NSW Department of Climate Change, Energy, the Environment and Water

Our ref: OUT24/16909

Subject: Billabong Creek Environmental Waters Regulators - SSI-50831979 – EIS

Detailed advice to DPHI Planning & Assessment regarding the Billabong Creek Environmental Waters Regulators - SSI-50831979 – EIS

TYPICAL SECTION THROUGH BLOCK BANK SPILLWAY SECTION
(APPROX CH 293.10 TO CH 318.10)

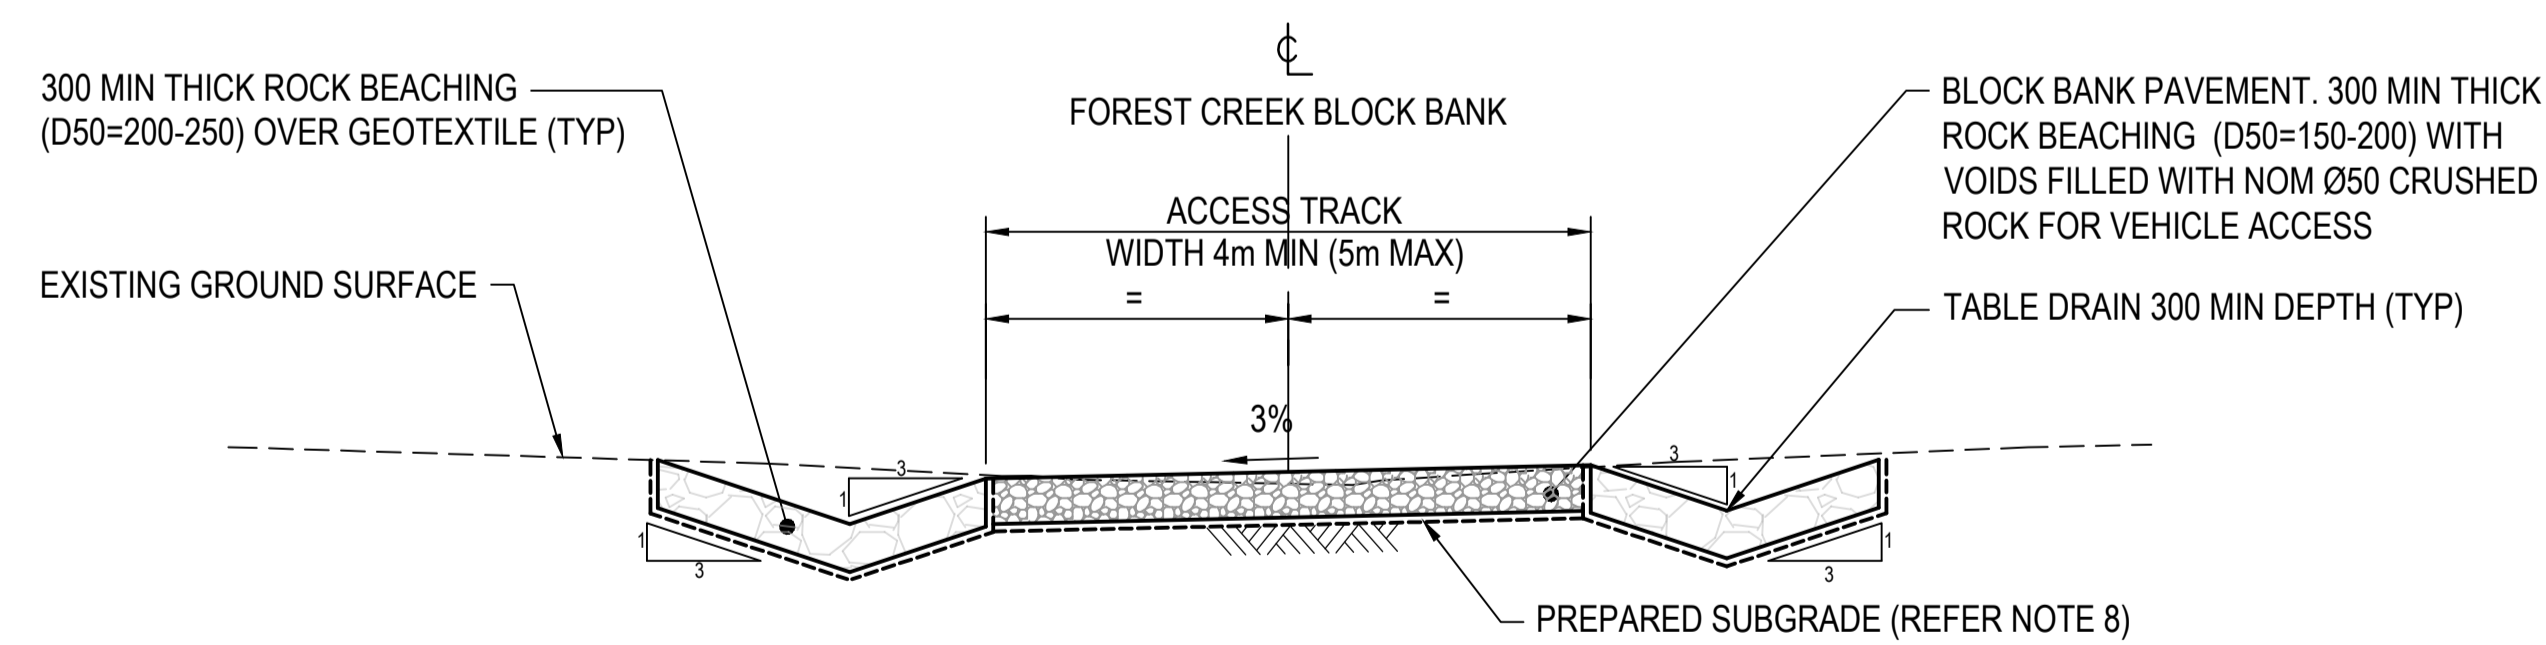
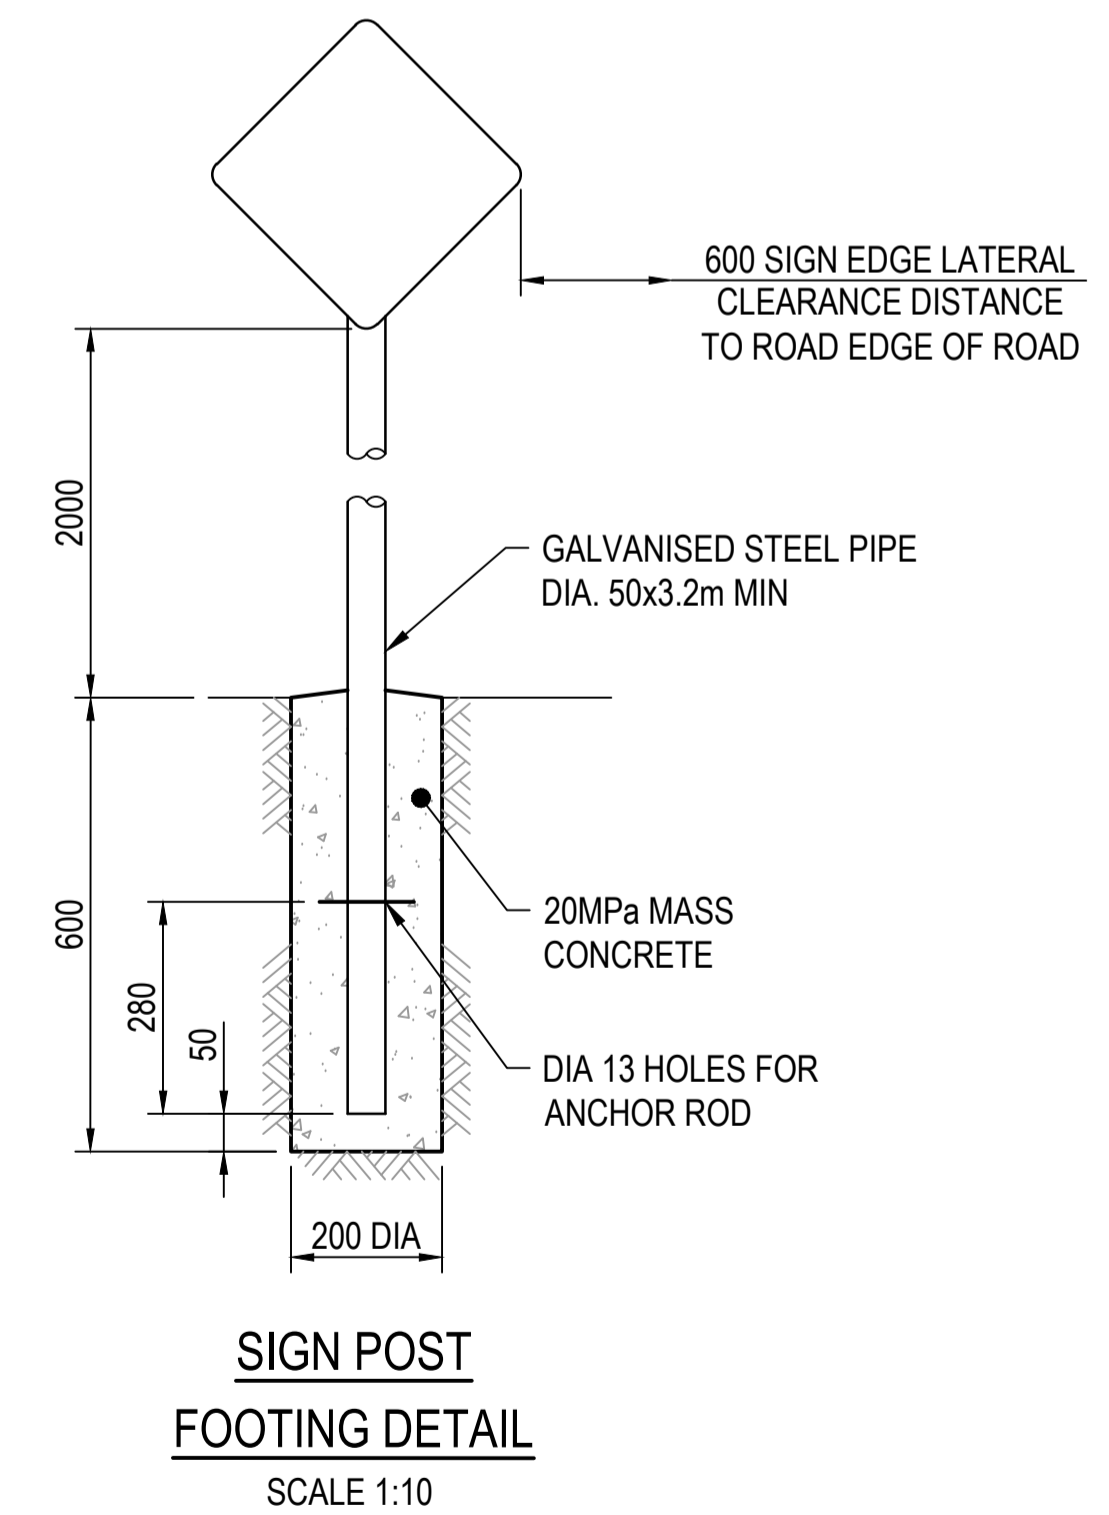
The proponent should provide further information on the design of the Forest Creek Block Bank.

Limited information has been provided to understand the proposed design of the block bank and what exactly this structure is. NSW DCCEEW Water Group requests further information so we can review the structure's compliance with the Guidelines for Controlled Activities on Waterfront Land and any associated water take. Confirmation of the proposed design and proposed works is requested.
